From: Amanda Scholes on behalf of Planning.Responses
Sent: 22 December 2017 09:55
To: Planning Scanning
Subject: FW: Planning Application AW/328/17/OUT - 14 Princess Avenue - Aldwick
Attachments: 14 Princess Avenue - Lettter to Arun District Council 1a - 21 12 2017.doc; Image 1 - Arcs of Overlooking from proposed development 14 Princess Avenue.jpg; Image 2 - Massing and overlooking of La Casita & Seagull.jpg; Image 3- Massing and Overlooking of Seagull.jpg; Image 4 - Overlooking at Seagull showing new high level windows.jpg

RE: Planning Application - AW/328/17/OUT – 14 Princess Avenue – Aldwick

Would you please take this letter as formal notice of a number of strong objections we have to the above planning application which seeks to convert the existing single dwelling at 14 Princess Avenue, Aldwick into five flats.

Drg No.: SBS/221/03C

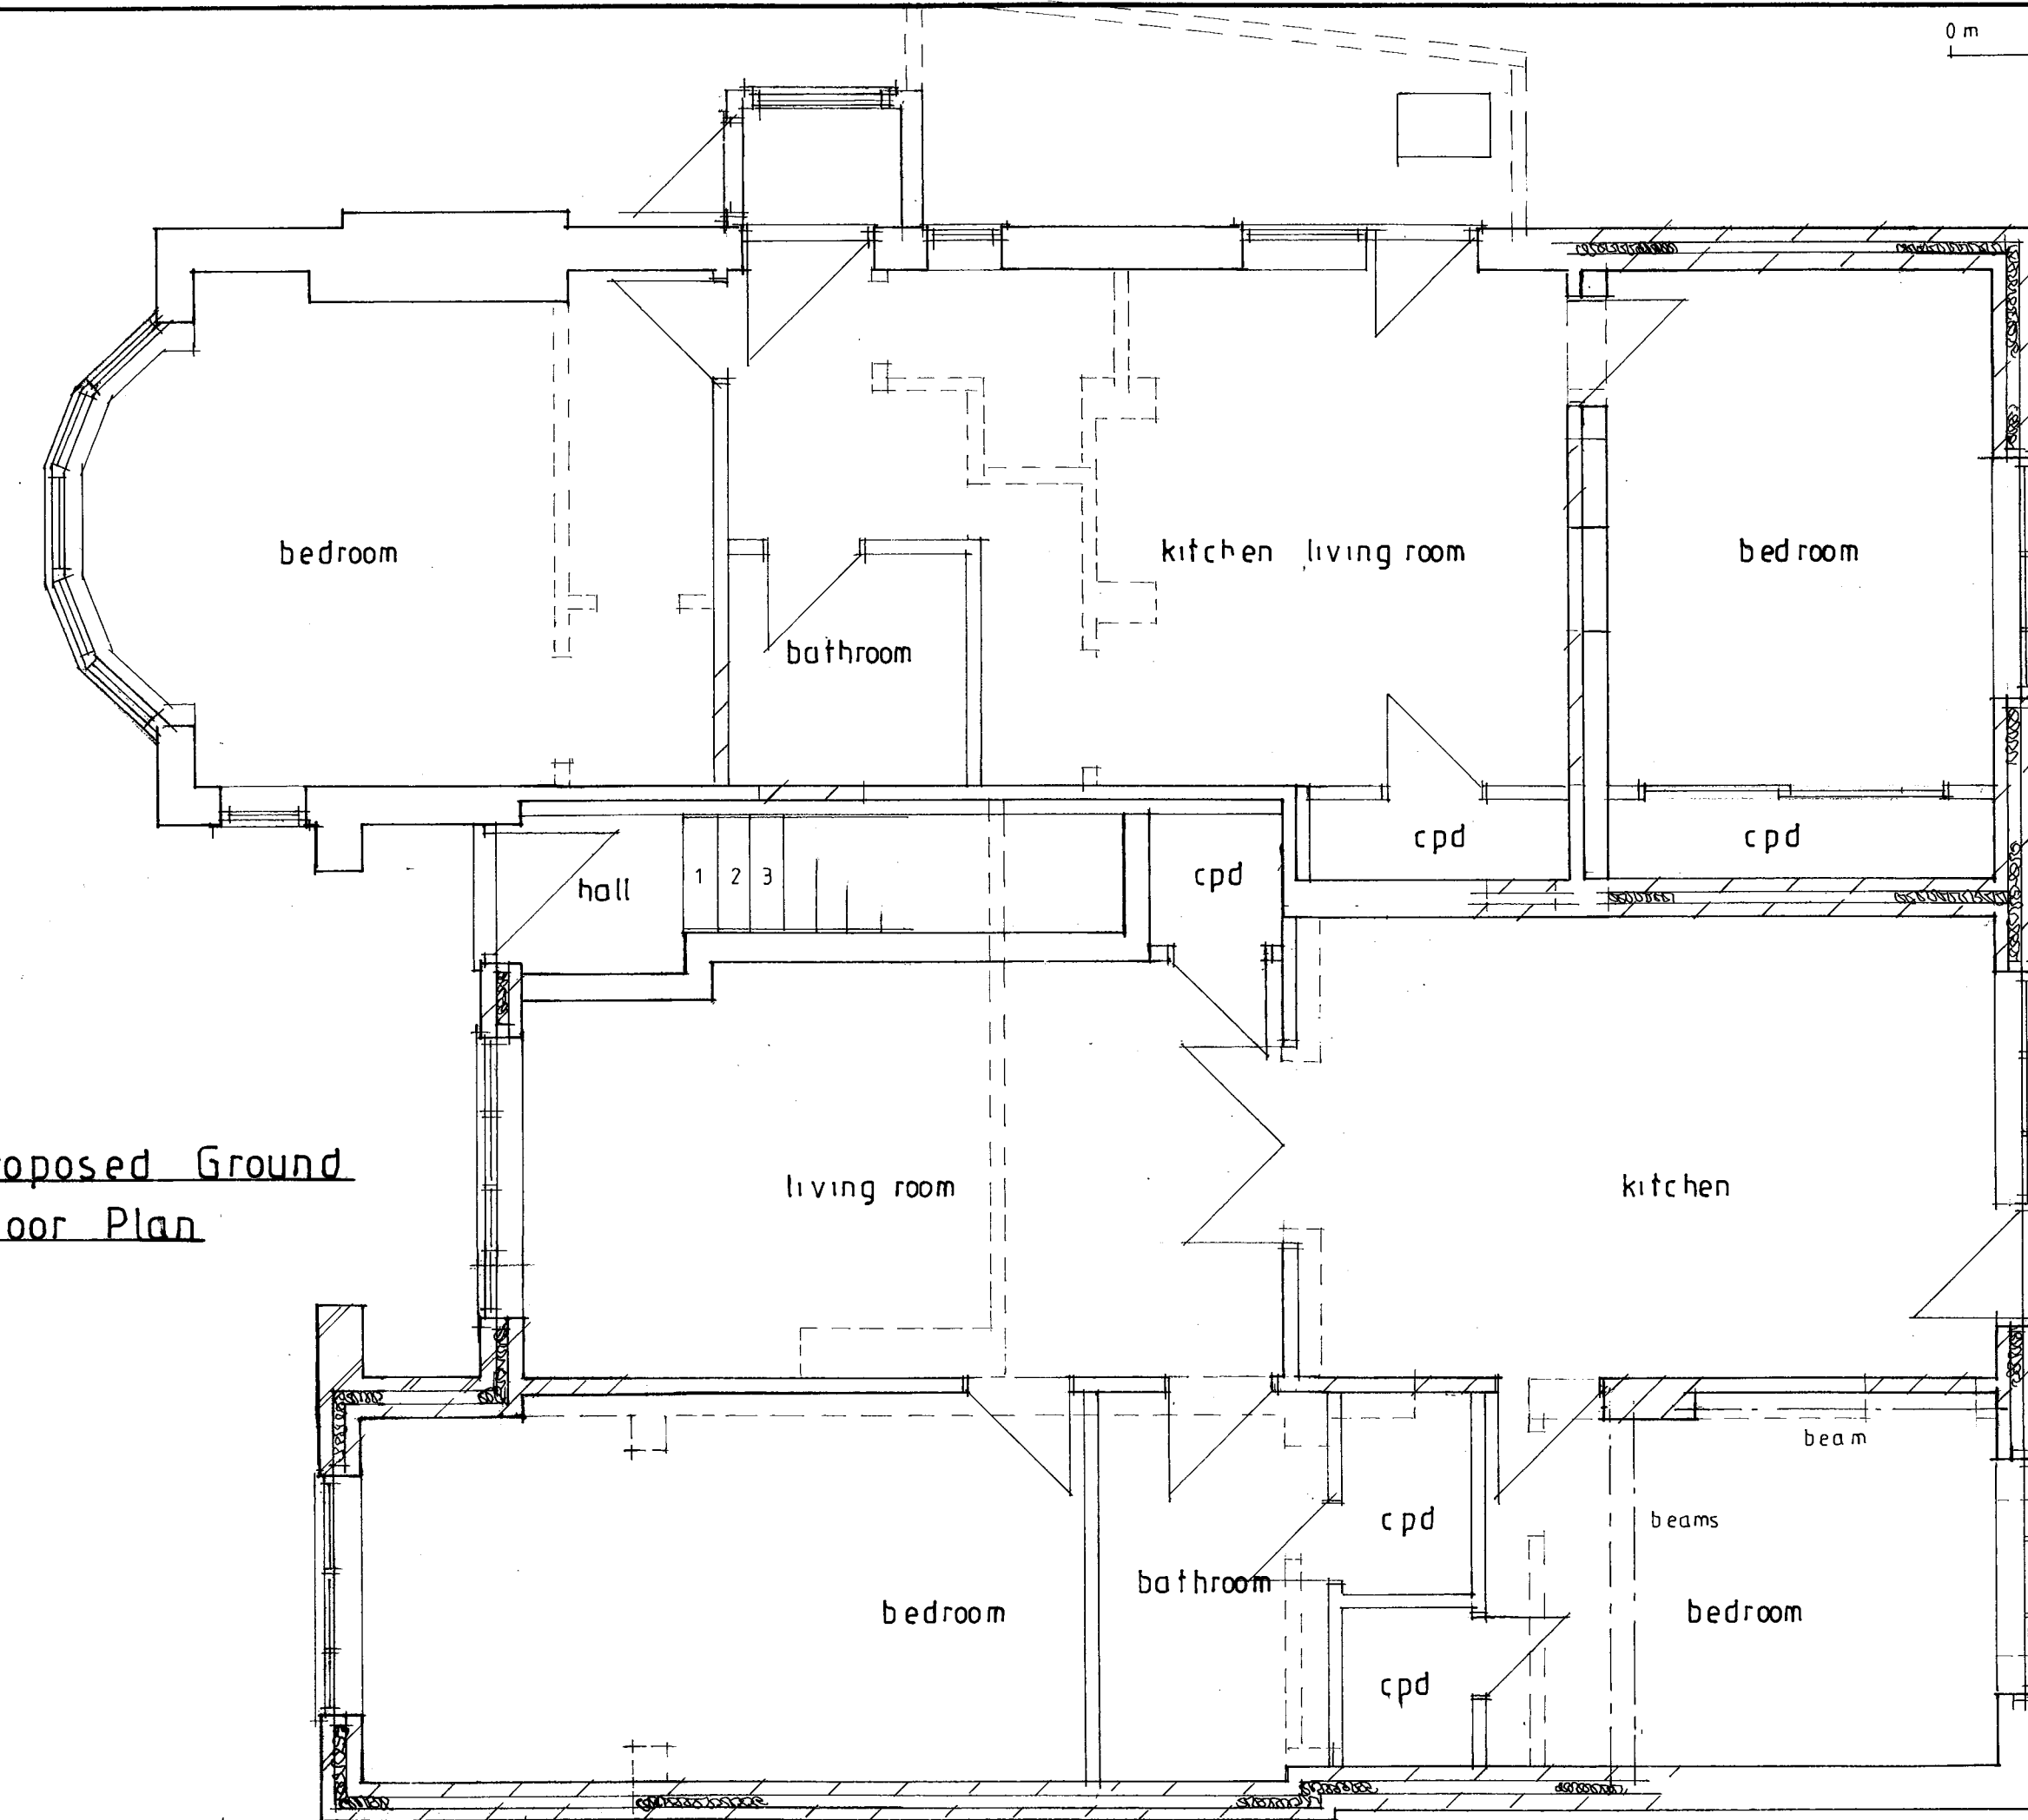
There is a additional problem which will worsen bin noise. All bins will have to pass through a narrow 'pinch-point' in the concrete passage way from the bin store to the road and back on the north side of the proposed development. It is inevitable that wheelie bins will crash into walls and fences and each other as they are man-handled on their way to road or bin store. Unfortunately Drawing No. SBS/221/10A entitled Proposed Flat Conversion – Site Plan is not accurate and does not show the 'pinch-point' which is between the external porch to Flat 1 - the Ground Floor North Side Flat and the boundary with the property to the north – 16 Princess Avenue. The gap between the porch to Flat 1 and the boundary with 16 Princess Avenue can be seen in the photograph Appendix X1 – and appears to be less than a metre in width. The Applicant does however show the narrow 'pinch-point' in Drawing No. SBS/221/03B – Proposed Ground Floor Plan.

Careful examination of Drawing No. SBS/221/03B – Proposed Ground Floor Plan shows that the sole entry for Flat 2 on the Ground Floor is by a doorway from the garden at the rear of building. This means there will inevitably be movement and noise potentially at any time of day or night from the road round to the door at the back of the house. Currently there is no such access and neighbouring properties enjoy quiet at the rear of their properties with neither sound nor intermittent lighting at night.

The narrow access point also represents a safety hazard. In an emergency the only way to gain entry to Flat 2 for Fire or Ambulance personnel would be from the rear of the property via the narrow pathway from Princess Avenue. It would be difficult to extricate an injured person on a stretcher or in a wheelchair from Flat 2 because the pinch-point inhibits such access. The kitchen for Flat 2 is at the restricted rear entry doorway. Making the kitchen of Flat 2 hard to access for Fire or Ambulance personnel is not only thoughtless; it is irresponsible. We believe that the design of Flat 2 and its entry point represent an unacceptable safety risk as well as being a most likely source of noise and night-time light disturbance for neighbouring properties.
